**From:** Rael, Rudy E.  
**Sent:** Wednesday, March 22, 2017 10:07 AM  
**To:** 'David Soule (david@riograndeengineering.com)'  
**Subject:** 6309 Alderete NW

Based upon the information provided in your submittal received 3/21/17, the above referenced Grading and Drainage plan dated 3/20/17 cannot be approved for Grading Permit or Building Permit until the following comments are addressed:

Project Title: 6309 ALDERETE CT NW Building Permit #: City Drainage #: D10DC03E 18  
DRB#: EPC#: Work Order#:   
Legal Description: lot 18 block 8 volcano cliffs UNIT 22  
City Address: 6309 ALDERETE CT

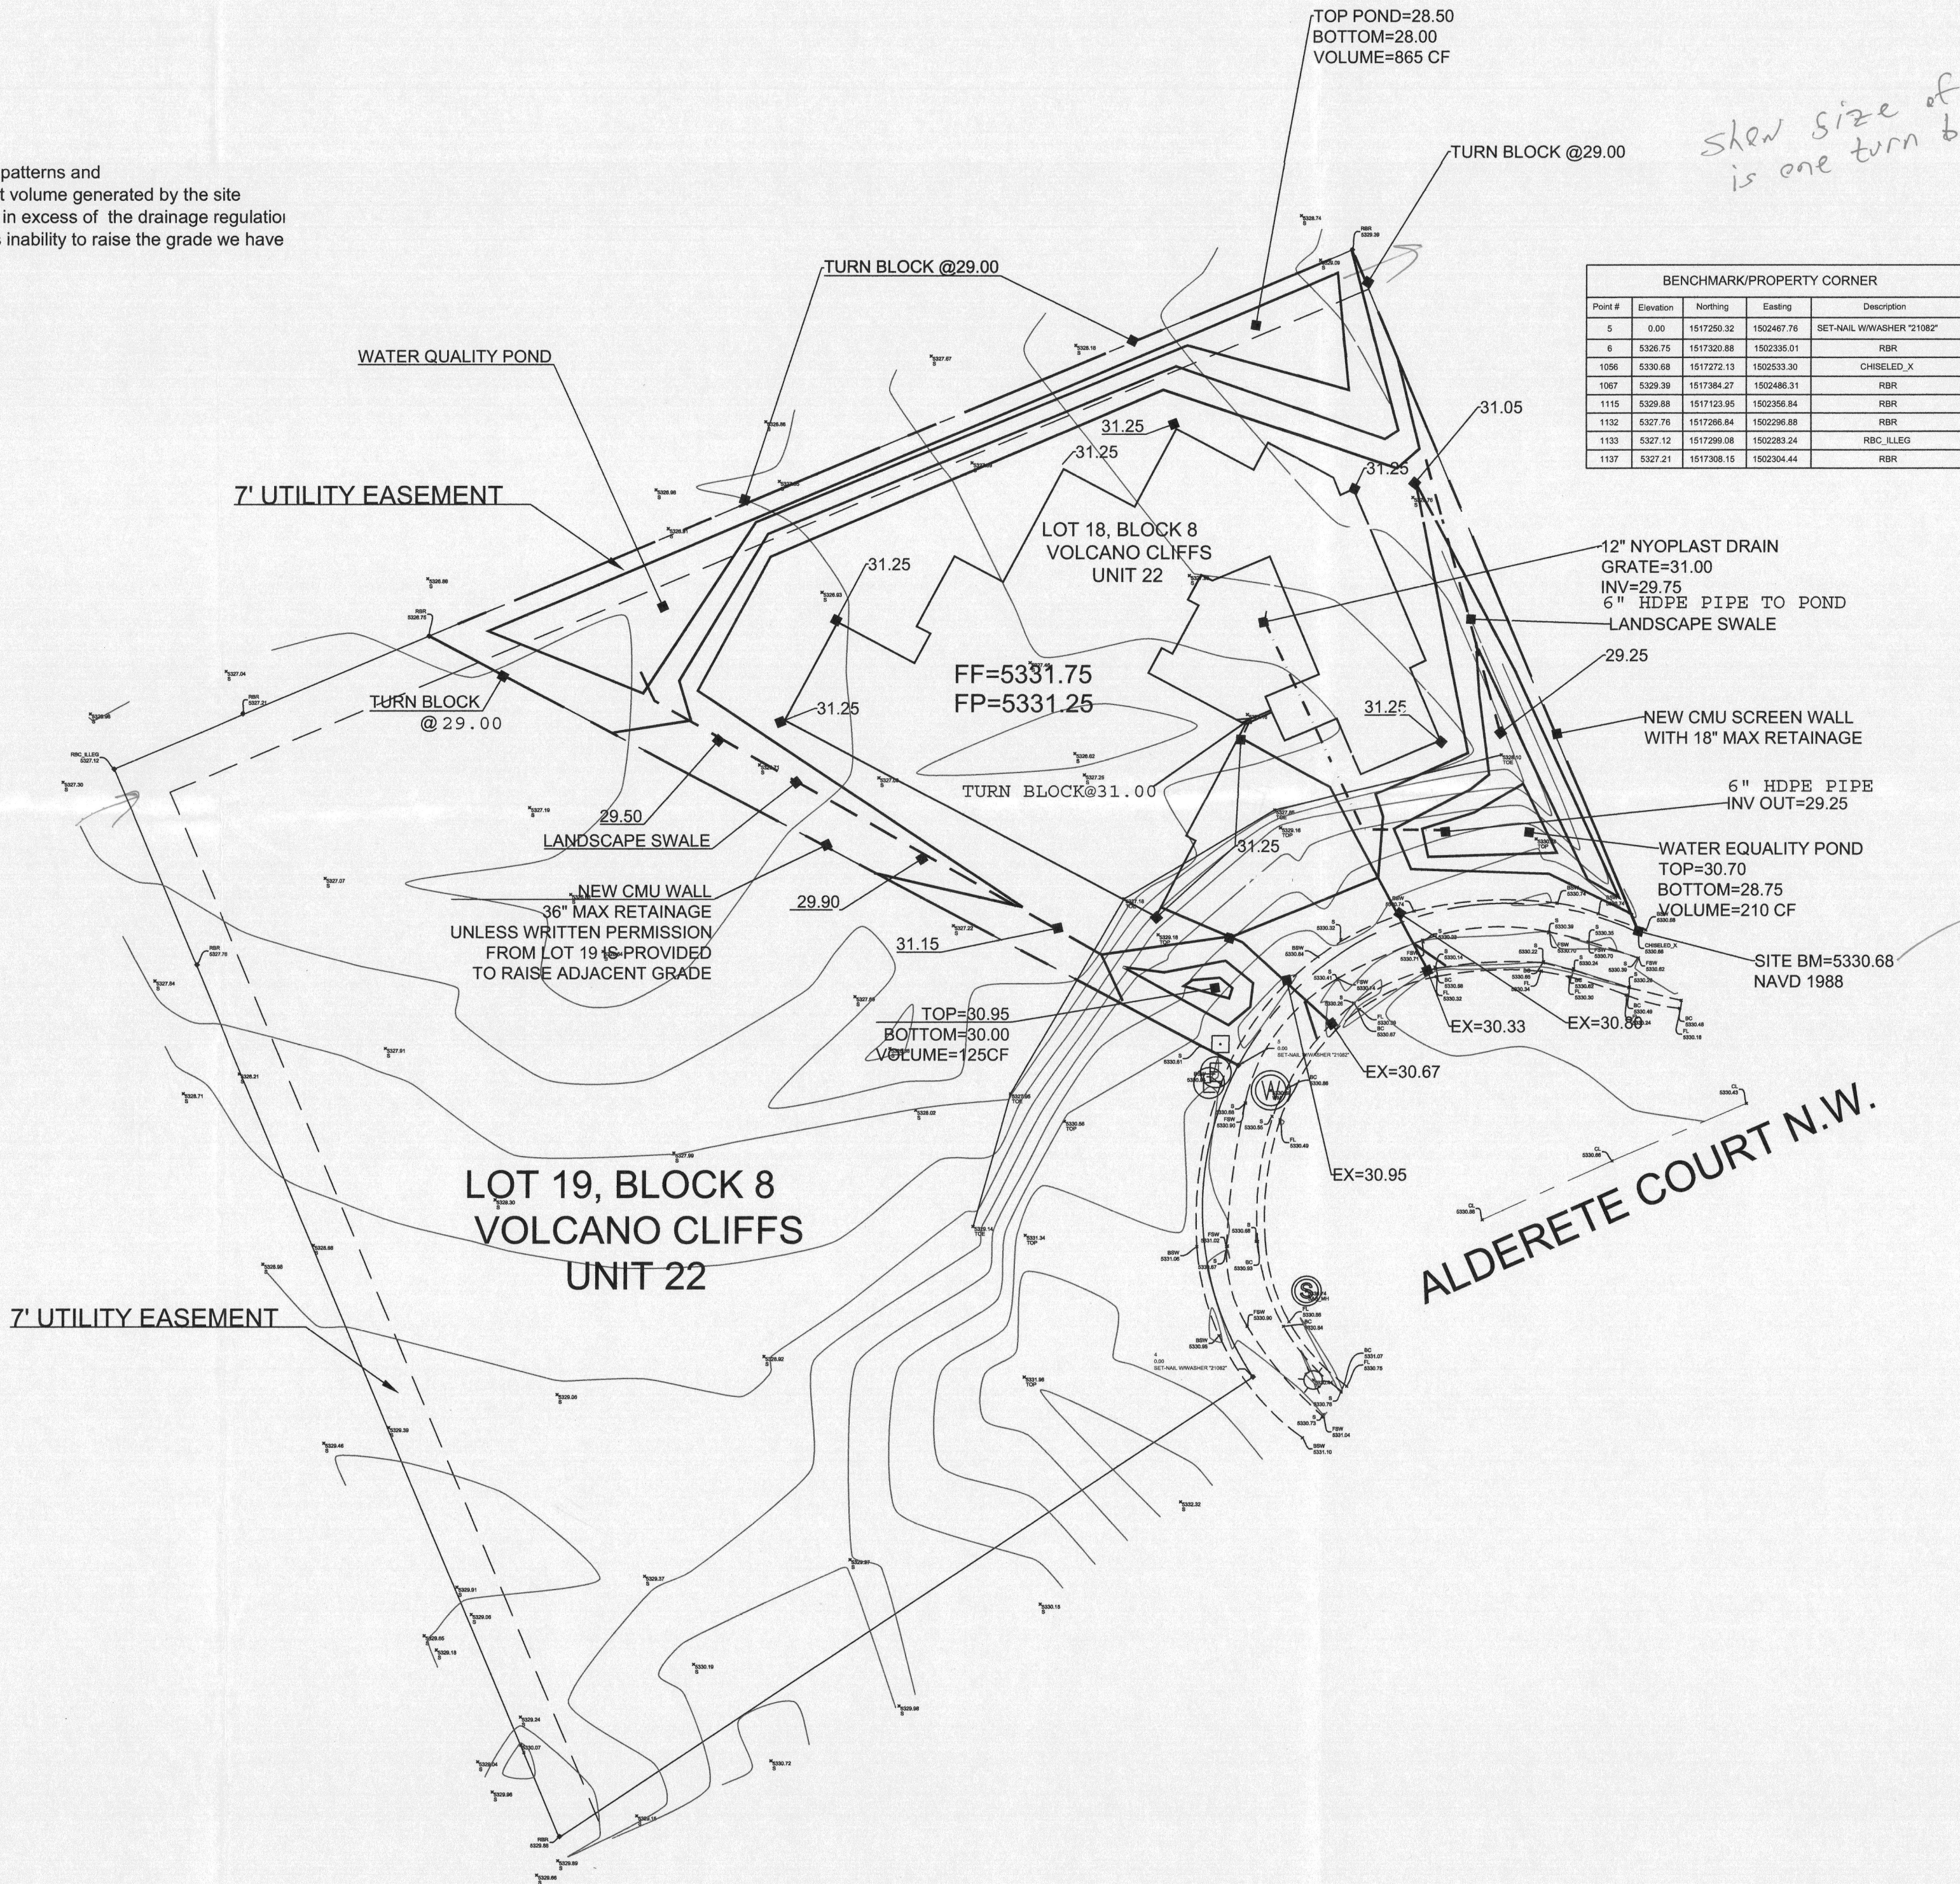
- Provide a statement explaining retaining walls or garden walls require a separate permit and this plan must be followed and supplied during the permitting process.
- Provide a statement that a pad certification is required before building pad is poured. In Bolden letters if possible.

Shahab asked that calcs are provided showing the size of openings in any wall provided are sufficient.
